**Consultation Response from KC,  
Highways Development Management**

**2025/91307 land at, Union Street, Heckmondwike, WF16 0HL**

**Erection of warehouse (B2/B8)**

**Date Responded: 15-7-2025.**

**DESCRIPTION:**  
 SITE PLAN

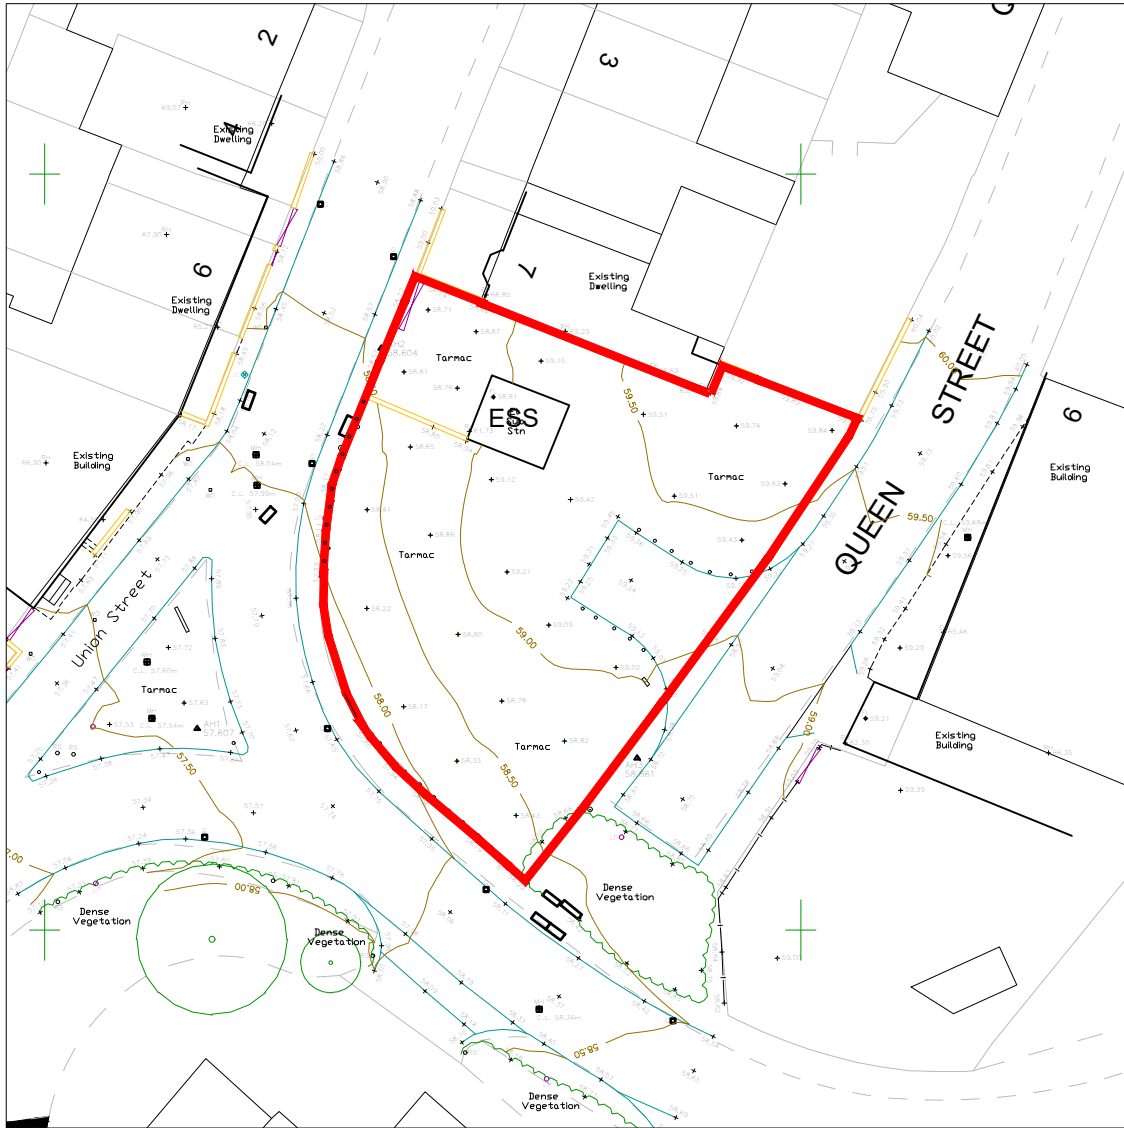
The proposed Site Plan shows a new Commercial Unit to the south side of the site, an existing electricity sub-station to be retained, a bin store, 6 off-street parking spaces and internal turning for a 7.5 tonne vehicle.

Access is shown from Queens Street.

The existing turning to Queen Street and footway to the site frontage is shown to be retained

As stated in the pre-application advice in general Kirklees Council has not set local parking standards for residential and non-residential development, any application should therefore include a justification of the proposed number of off-street parking spaces and justify the loss of existing parking at this site.
